Modification to Redisand Salt Ash Sand project approval 07_0094 Response to Submissions

April 2018

Redisand Pty Ltd

Figure 4 | Location of Nelson Bay Road/ Janet Parade intersection

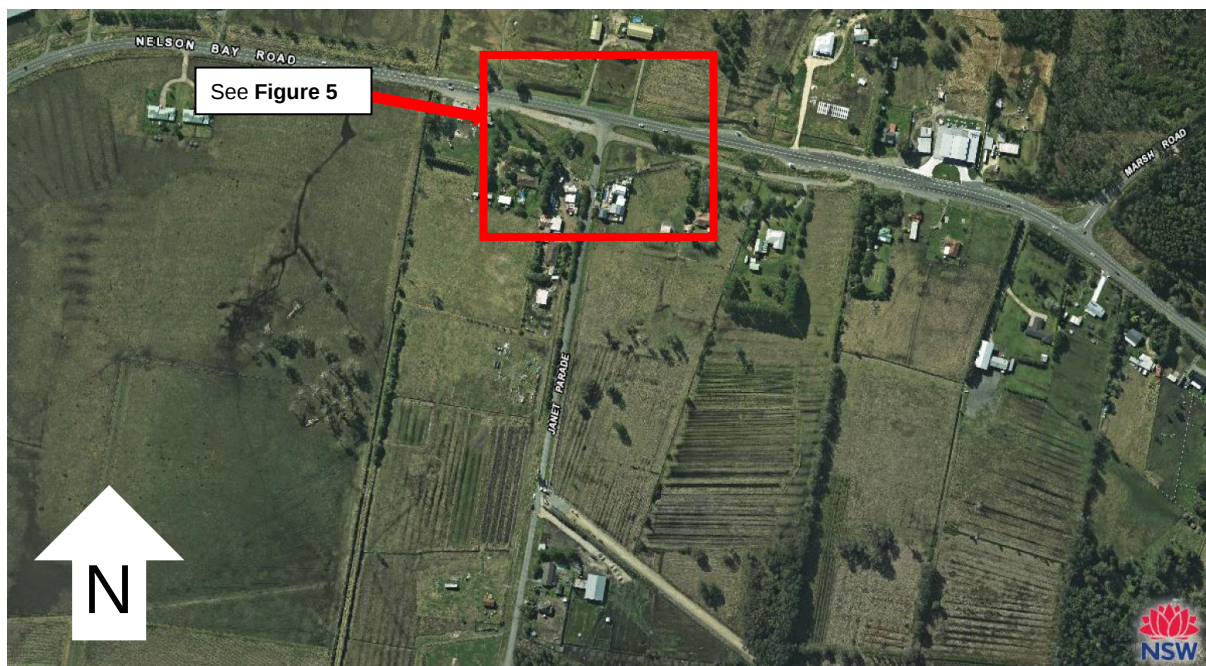
Transport Roads & Maritime Services	
<ul style="list-style-type: none"> The intersection of Nelson Bay Road and Janet Parade shall be upgraded to comply with the intersection warrants within Section 2.3.6 of Austroads Guide to Traffic Management Part 6: Intersections, Interchanges and Crossings. 	<ul style="list-style-type: none"> It is considered that this upgrade is not required due to the following reasons: <ul style="list-style-type: none"> The intersection of Janet Parade and Nelson Bay Road was upgraded as part of the approval process for the current sand mining operations. This was in 2012 and the intersection upgrade was approved by the RMS at that time. Since this upgrade has been in place, there

<p>have been no recorded accidents at this intersection and the current mining operations have been in operation;</p> <ul style="list-style-type: none"> ○ The current approval allows for 3 laden trucks per hour to exit the site (and a similar empty number of trucks to enter the site via Janet Parade). The proposed expansion will increase the hours of operation and will generate an average of 4 truck movements per hour entering (and exiting) the site. This represents an increase of just one truck per hour per direction and is considered to have a minimal impact upon the operation and safety of this intersection as such; ○ The requirement to provide a channelised left turn lane for traffic turning off Nelson Bay Road into Janet Parade is not warranted at all by the project, as all trucks associated with the project will be turning right into Janet Parade off Nelson Bay Road and then exiting left onto Nelson Bay Road. There is no requirement for trucks to head east of the site so this upgrade is not justified as part of this project.

Figure 6 | Sensitive noise receivers surrounding Salt Ash Quarry

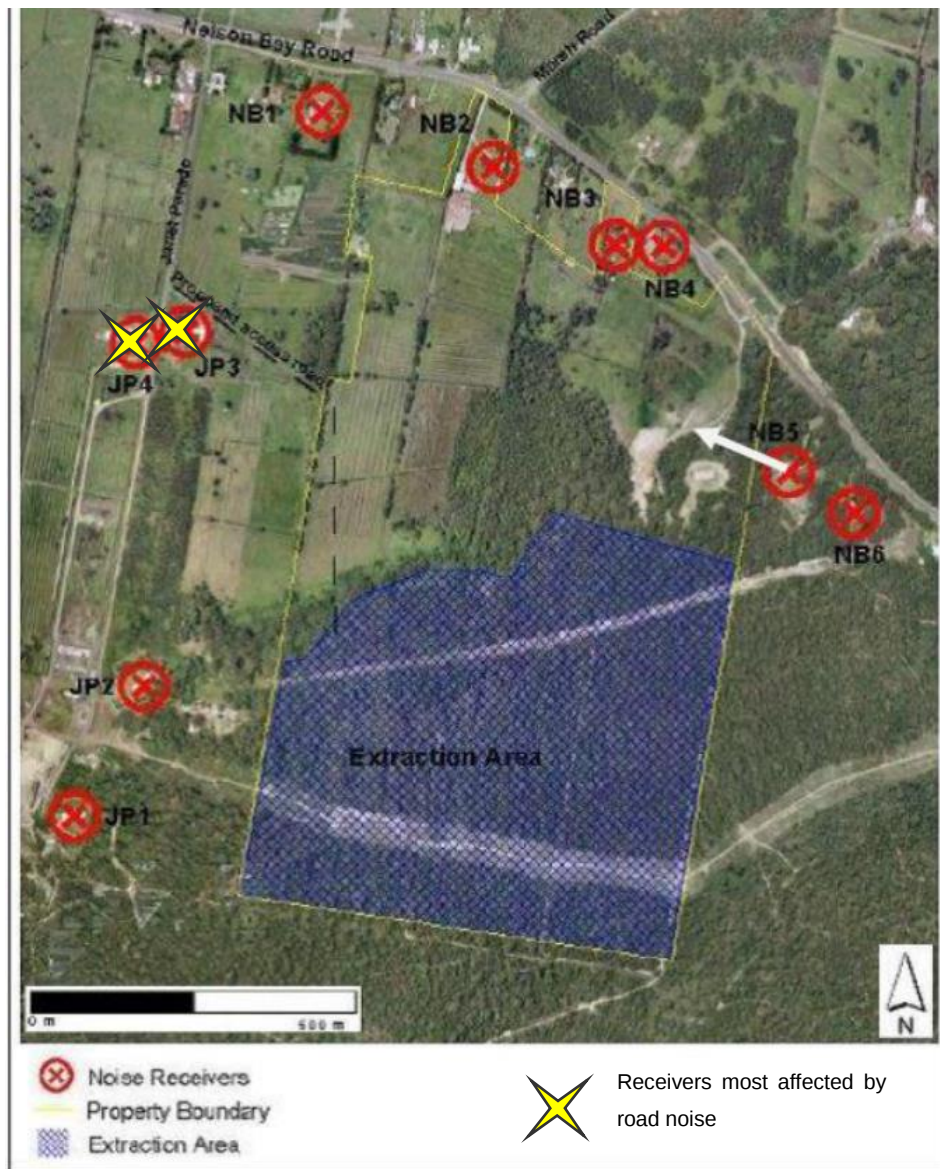
The NIA does not include an assessment of road traffic noise off-site from the increased truck movements on Janet Parade. However, the modification report states that there is community concern in relation to the increased noise and road safety issues that would arise if an increase in truck movements and operating hours were approved for the project.

The results of the noise modelling found that the existing and predicted traffic noise levels for quarry traffic along Janet Parade were calculated to be lower than the day period assessment criterion of 55 dB(A) $L_{eq,(1\text{ hour})}$.

Advitech Environmental understands that under the proposed quarry expansion plan, the quarry would extend the operating hours from 7:00 am to 5:00 pm, Monday to Friday to 6:00am to 6:00pm, Monday to Friday. It is noted that the period from 6:00 am to 7:00 am is considered to be part of the night period. The results of the modelling indicate that at the proposed volume of quarry vehicle movements, the night period assessment criterion of 50 dB(A) $L_{eq,(1\text{ hour})}$ would likely be exceeded at receiver R4.
